Re: Addison Galaxy FBO Civil Plan Review

Development: Galaxy FBO
Town Project #: 19-09D
Plan Review: 2nd Civil Submittal

Summary of Engineering Review Comments

Date: December 5, 2019
 Plan Review : Civil Review 2
 Received: November 13, 2019
 Plan Date: November 11, 2019
 Development: Galaxy FBO

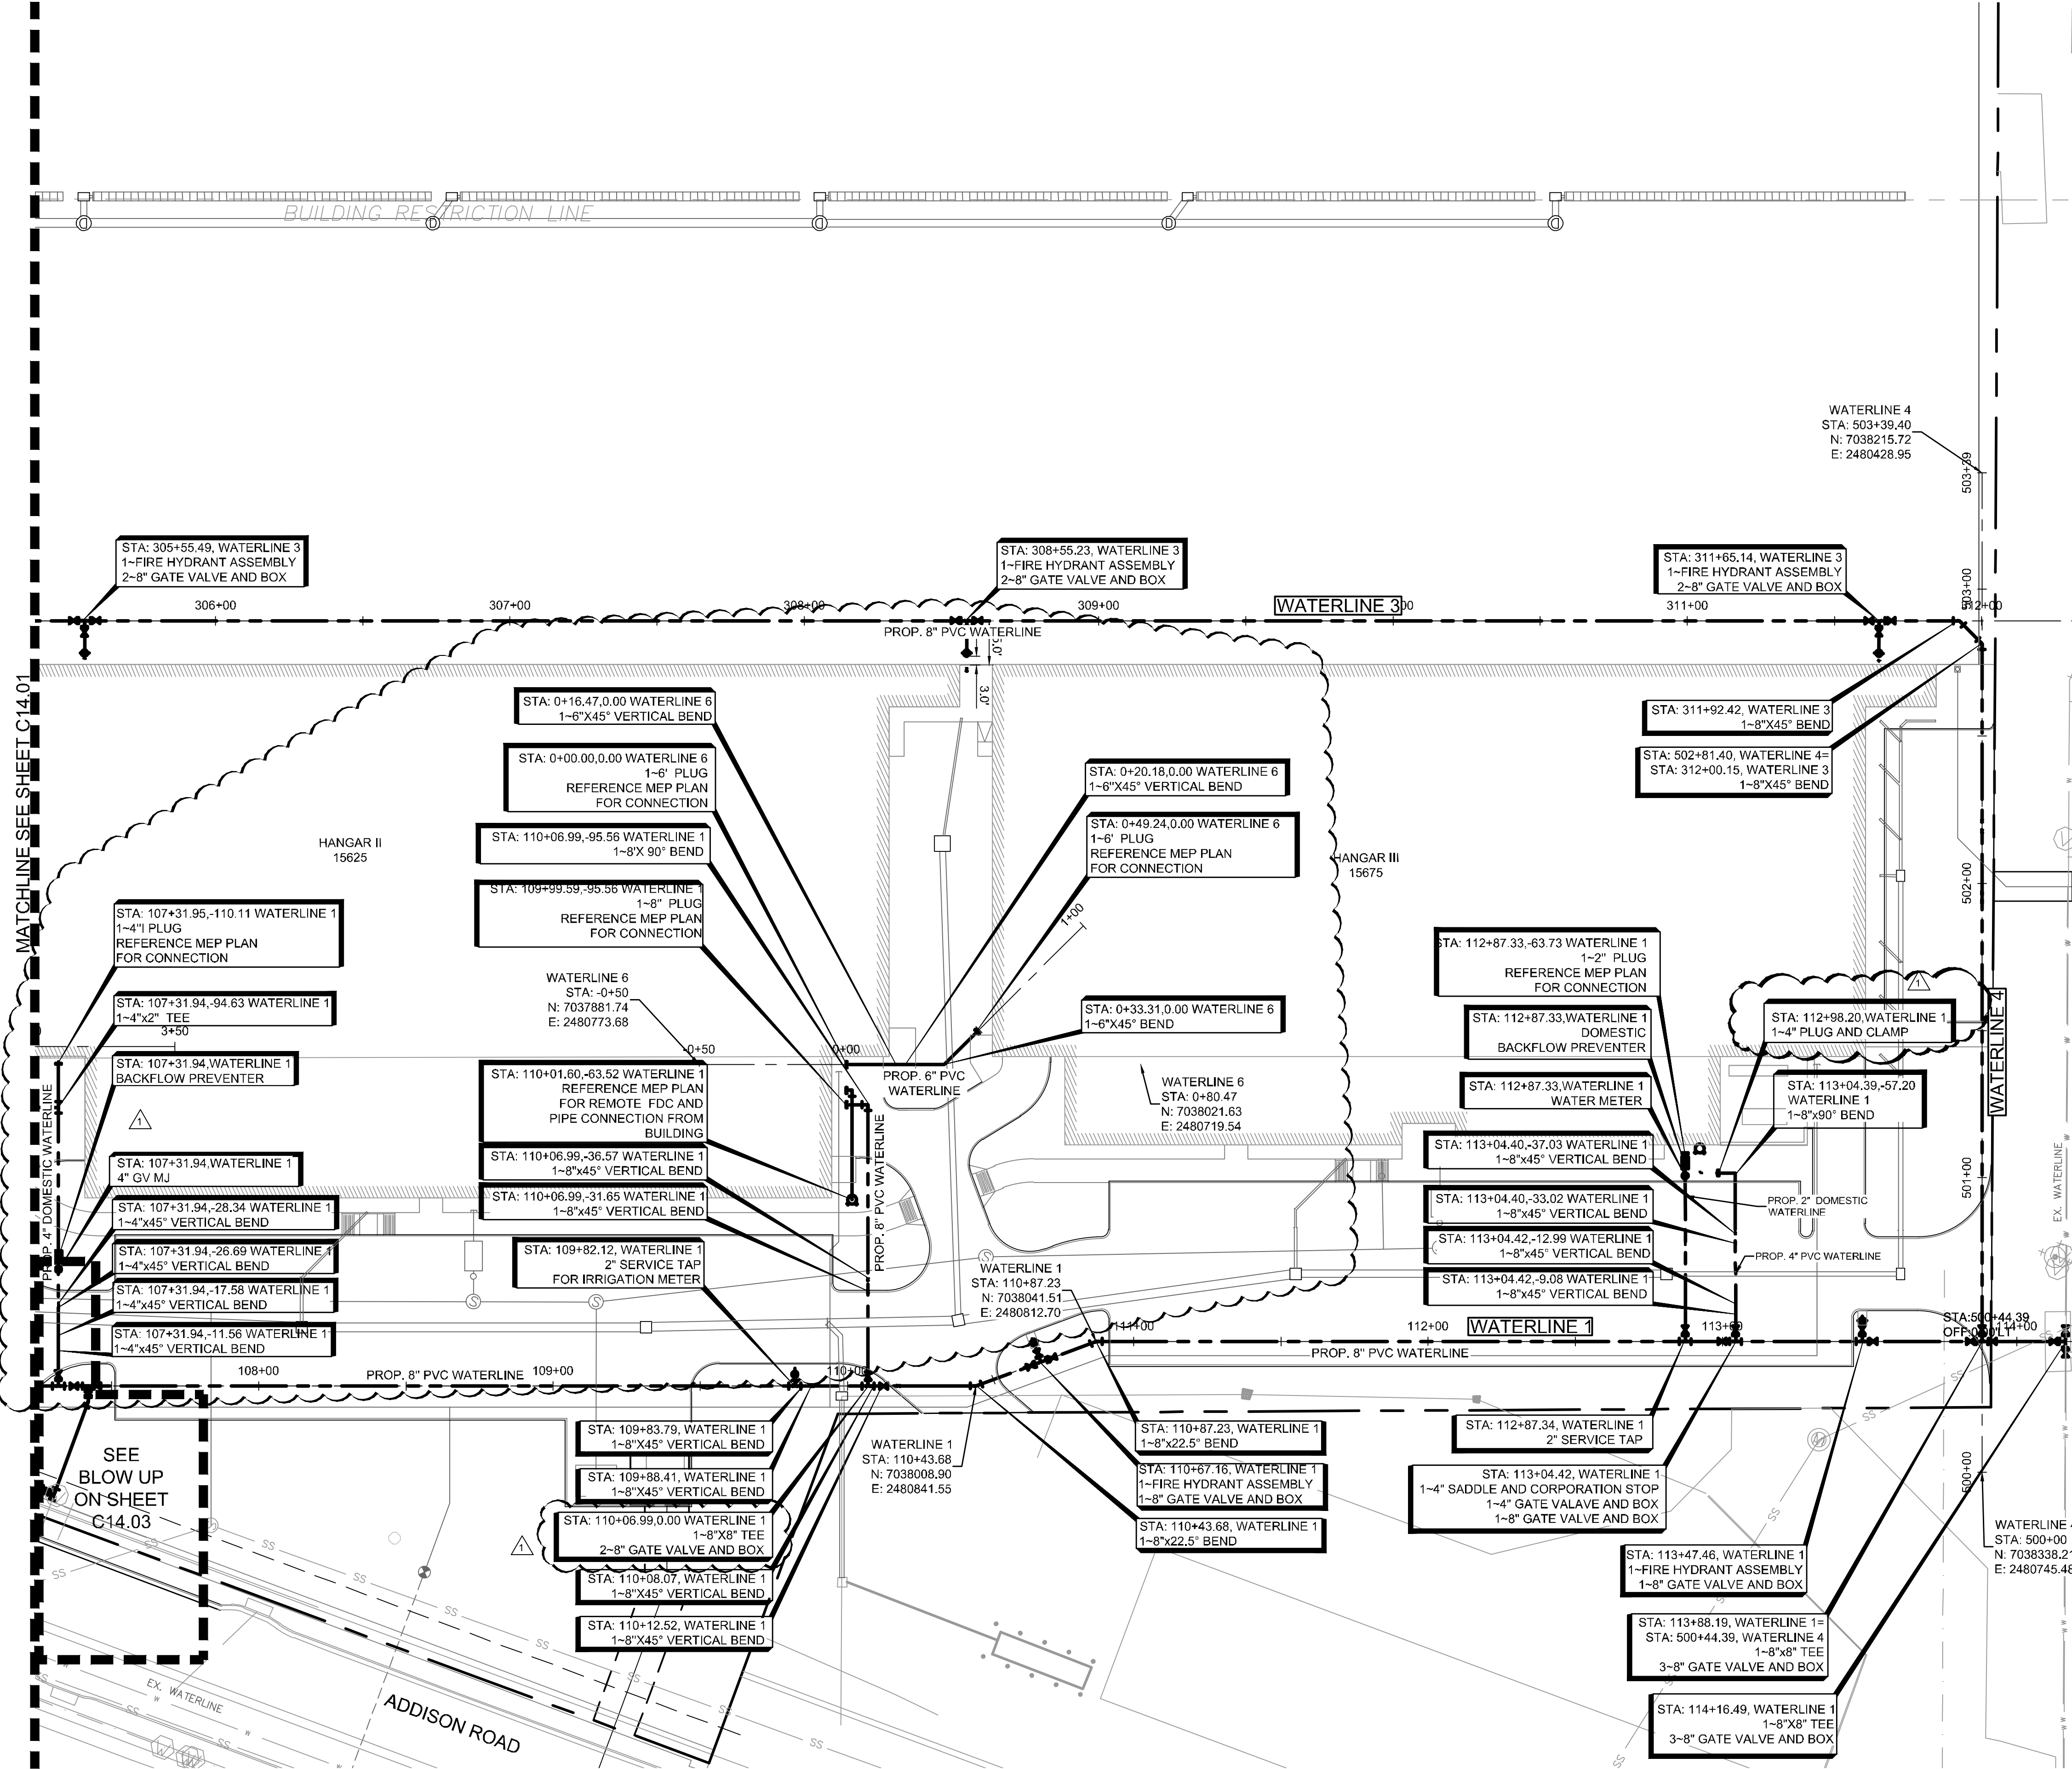
C14.02	Include blow-up detail of service tees & valves for Hangar 2 - placement on the page and proximity of the two services makes it hard to properly identify correct assembly.		
C14.02	Include a detail for the existing water line connection at Addison Rd - it is difficult to see what's happening b/c it's right on the match line.		
C14.02 & C14.04	WL-5 should be WL-4?		
C14.03	WL-2 profile has labels calling out WL-1 and is not showing the storm drain crossing.		
C14.04	WL-3 STA 300+50 does not have a label, but does have a revcloud. ???		
C15.00	Where are elec/telco/fiber/etc service connections & lines? Will there be transformers/cabinets/pedestals/meters, etc onsite that will need locations coordinated with other infrastructure & landscaping?		
C15.00 & C18.01	Show southern property line power pole relocation on this sheet, not C18.01		
C15.00	Is the one electrical service called out on the sheet the only electrical connection you will have? Where does the elec conduit run within the site? This service crossing needs to be identified/labeled as an underground crossing. Is the aerial crossing on the north side of the northern drive still necessary? If so, call for undergrounding the service line.

SHEET NUMBER  
**C15.00**

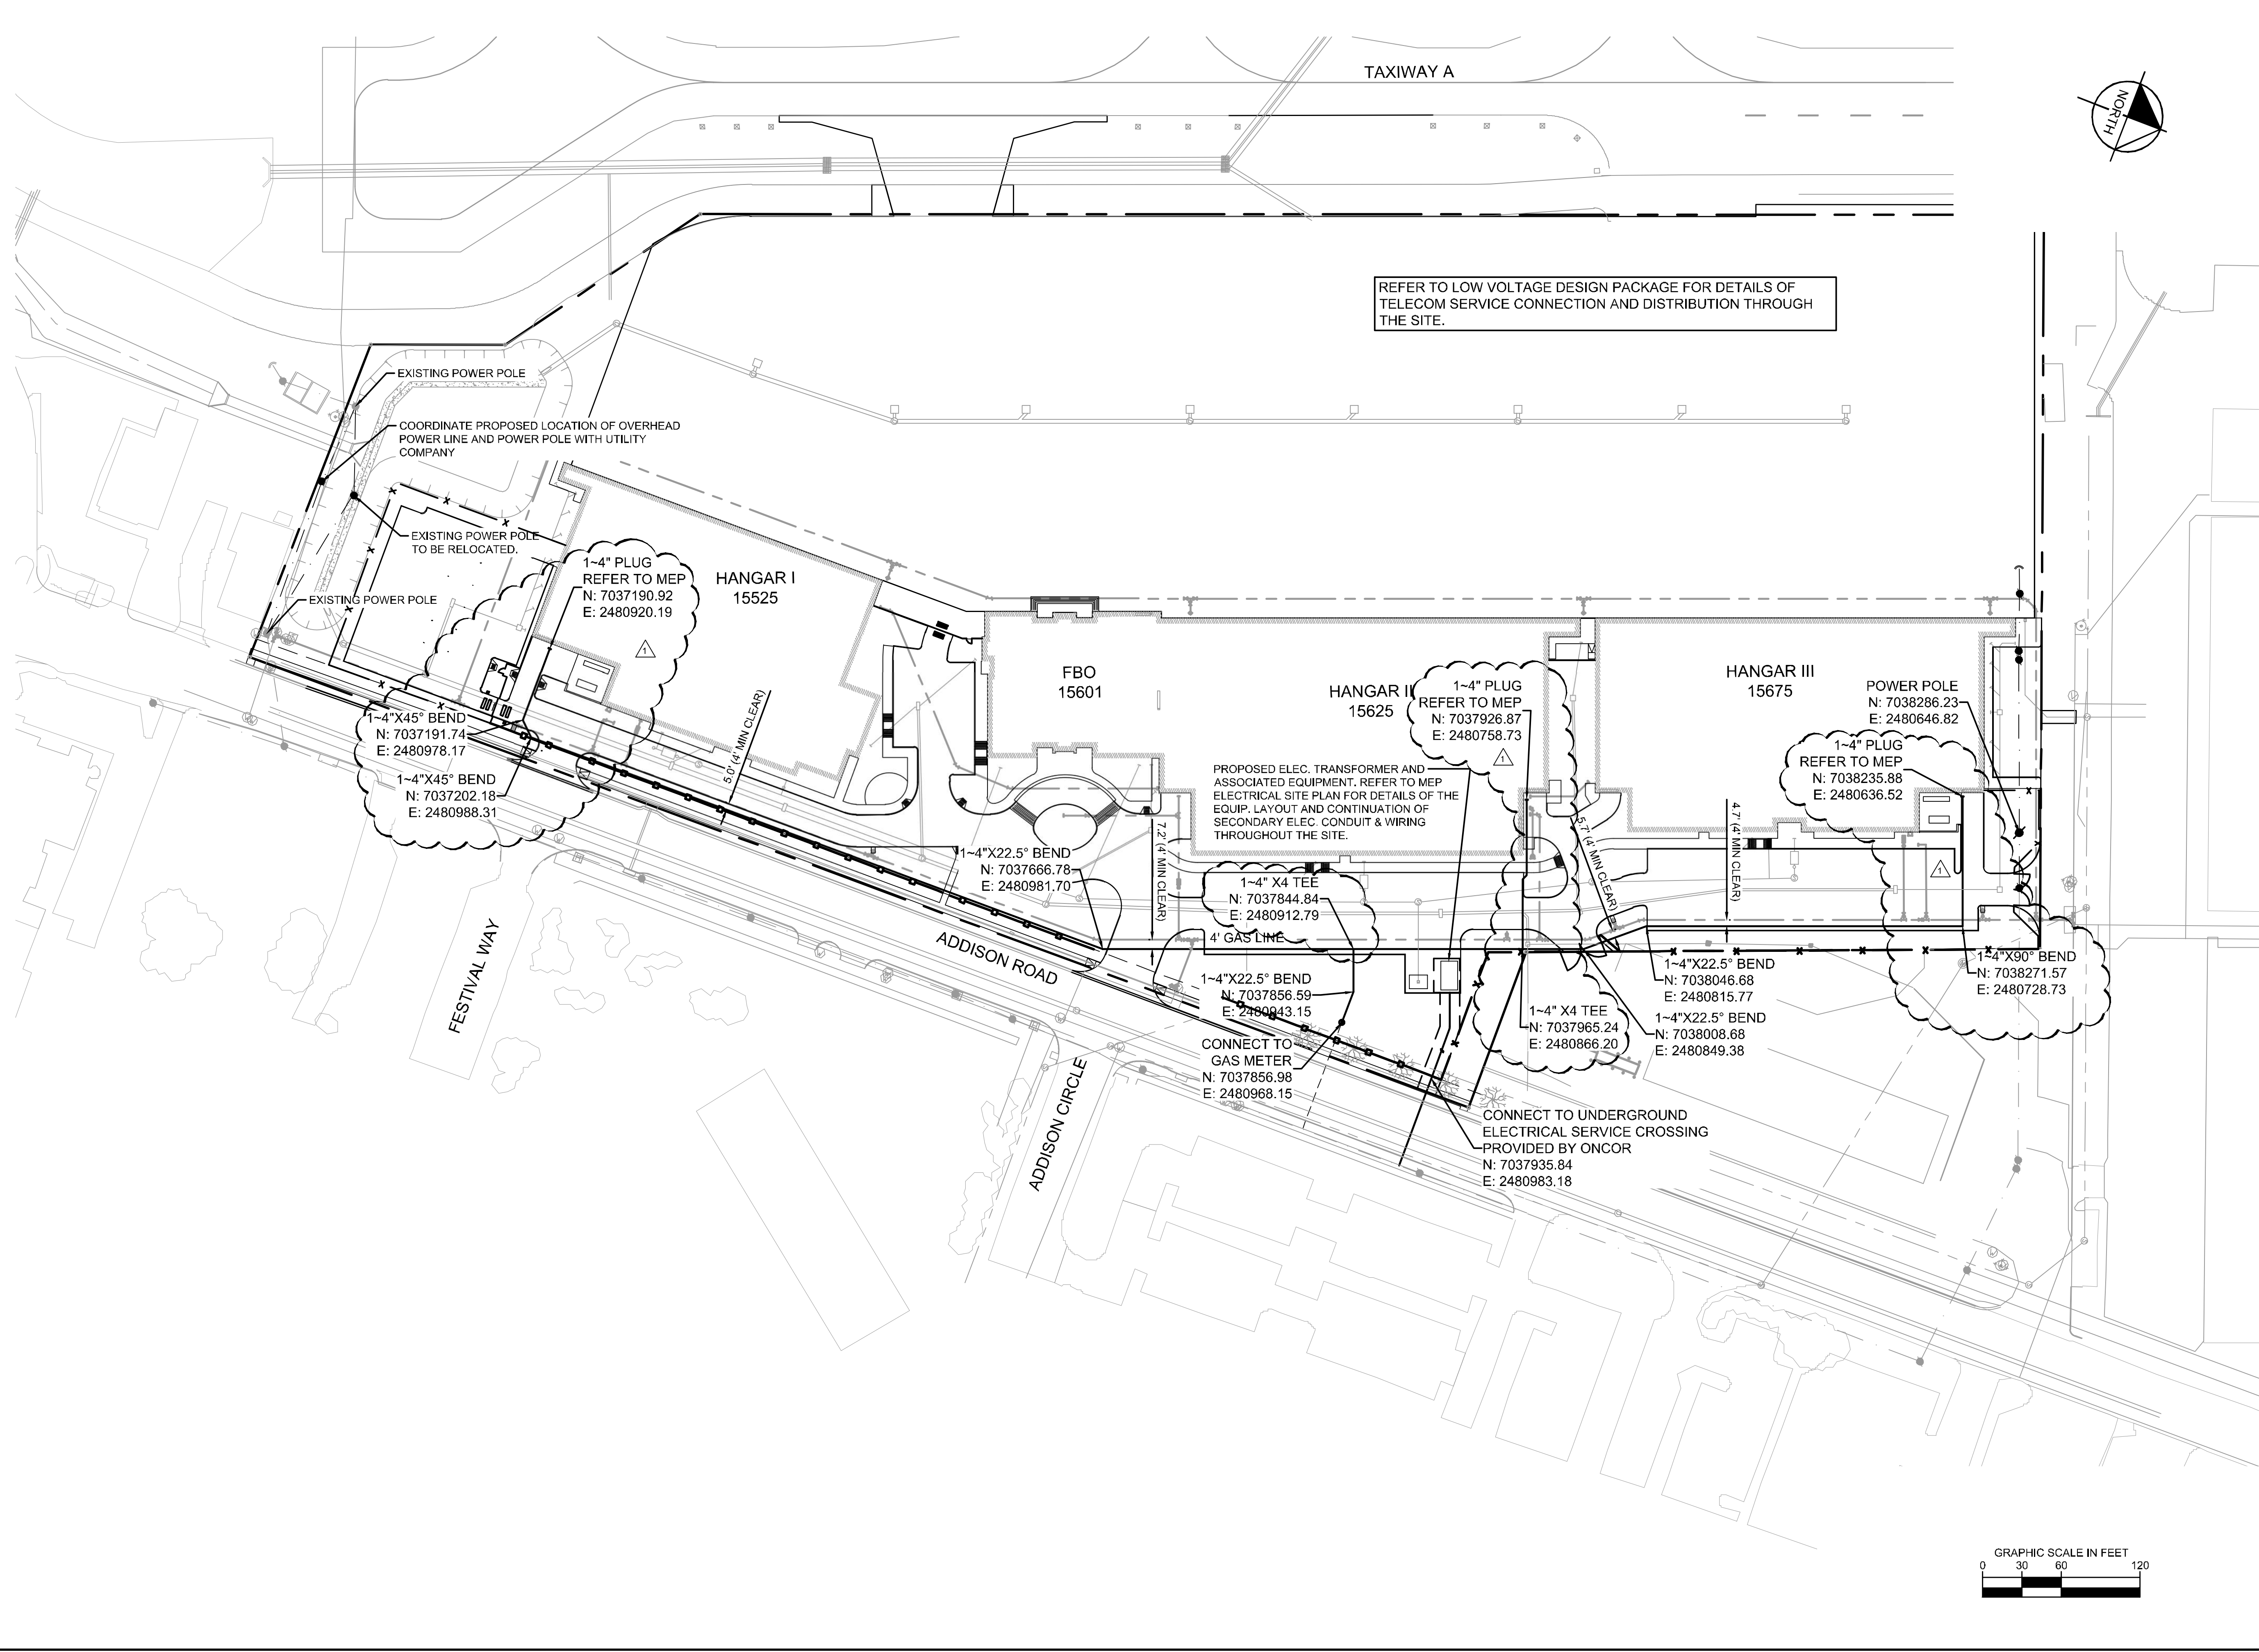
C15.00	PREVIOUSLY REQUESTED. Dimension the separation from the water & gas (min. 4')

SHEET NUMBER
C12.08

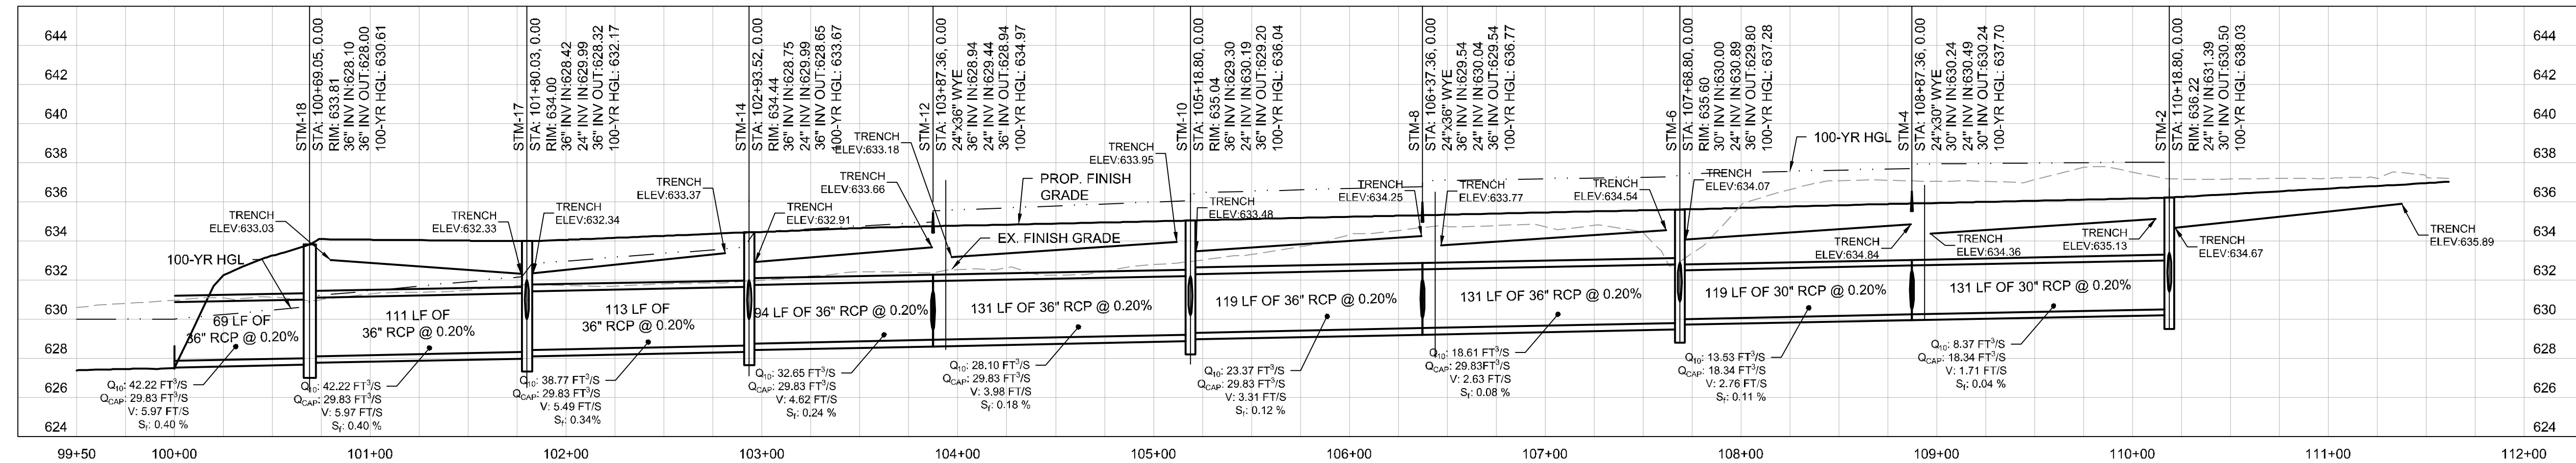
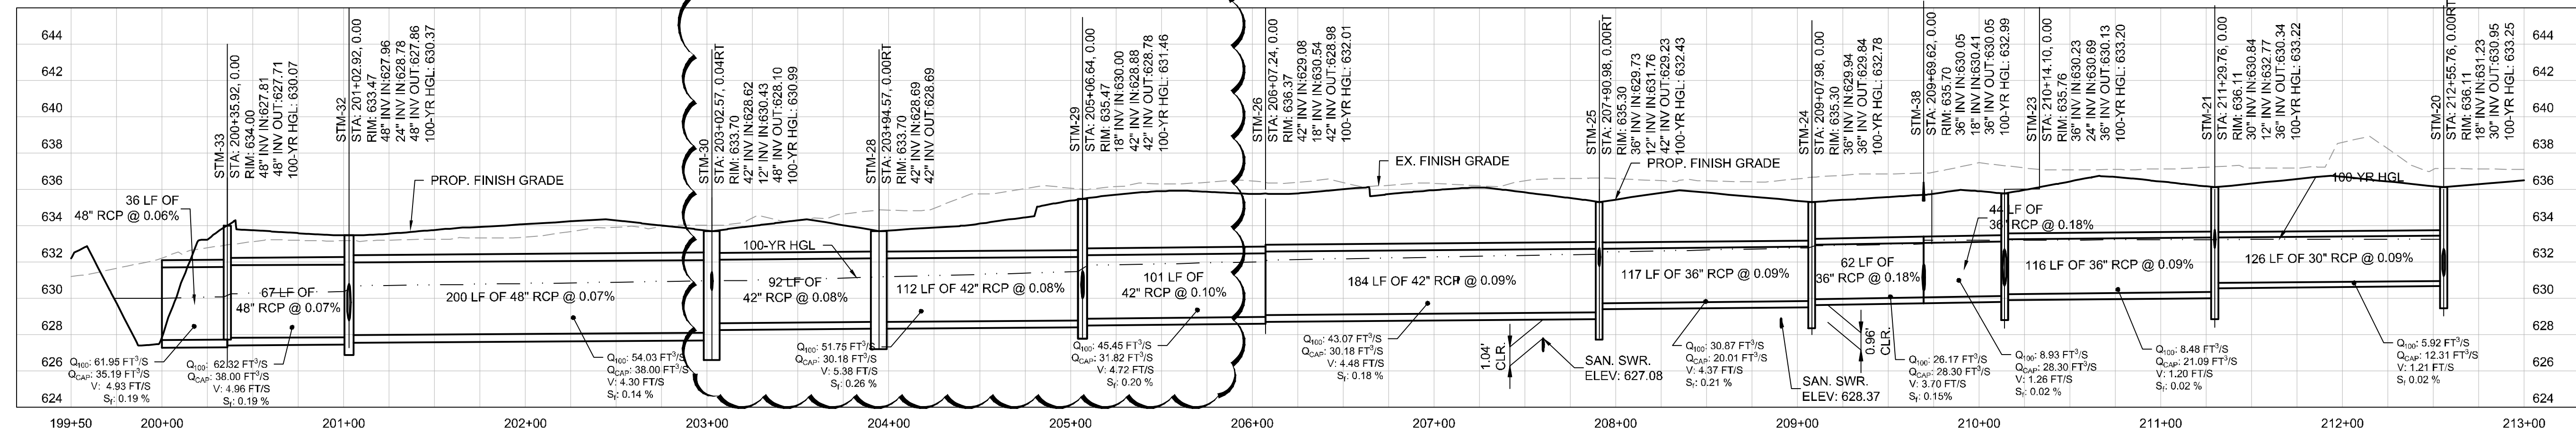
C12.XX	Add Note 6. Any HDPE pipe is considered private and will not be maintained by the Town.		
C12.01 & 12.08	Include ex culvert & ex culvert drainage info/calcs in channel profile		
C12.02 & C12.08	STM-18 should have a 0.10' foot drop between in/out inverts.		
C12.02-04 & C12.08	Trench drain inverts are not consistent between the plan & profile views.		
C12.03	STM-13 should have trench drain information call-out as shown on others		
C12.05 & C12.08	SD-3 alignment should follow the full length of the line & structures should be stationed off the SD-3 alignment, not SD-2. Include all pipe segments & structures in profile.		
C12.06 & C12.08	SD-5 alignment should follow the full length of the line & structures should be stationed off the SD-5 alignment, not SD-2. Include all pipe segments & structures in profile.		
C12.07	Identify & profile storm drain connecting to ex fuel farm drainage (SD-7?)

C12.08	Call out pipe sizes of the inverts (like in plan view)

Page No.	Comments	Response (See Note)	Explanation
C12.08	Show all utility service crossings.		
C12.08	PREVIOUSLY REQUESTED. Label HGL100 in profile callouts.		
C12.08	SD-1 : Your HGL100 looks like it's higher than proposed grade in places.		
C12.13	The Addison-specific storm manhole cover is no longer available. Call for a generic "flows to creek" in a note added to the existing standard detail.		
UTILITY	Add embedment notes from plan view sheets to profile sheets as well.		
SANITARY	Add civil cleanouts at the back of curb on all services & include TOA standard cleanout detail.		
SANITARY	PREVIOUSLY REQUESTED. Legend - why calling for a clamp?		
C13.01	Show 90bend on the the sanitary service out of Hangar 1 to indicate it will not cross the water services.		
C13.01	Why are you calling for DI on the 4"?		
C13.01	SAN-25 doesn't have a station in the callout		
C13.02	Identify SS-4 in plan view		
C13.02	SAN-32 : check invert elevations
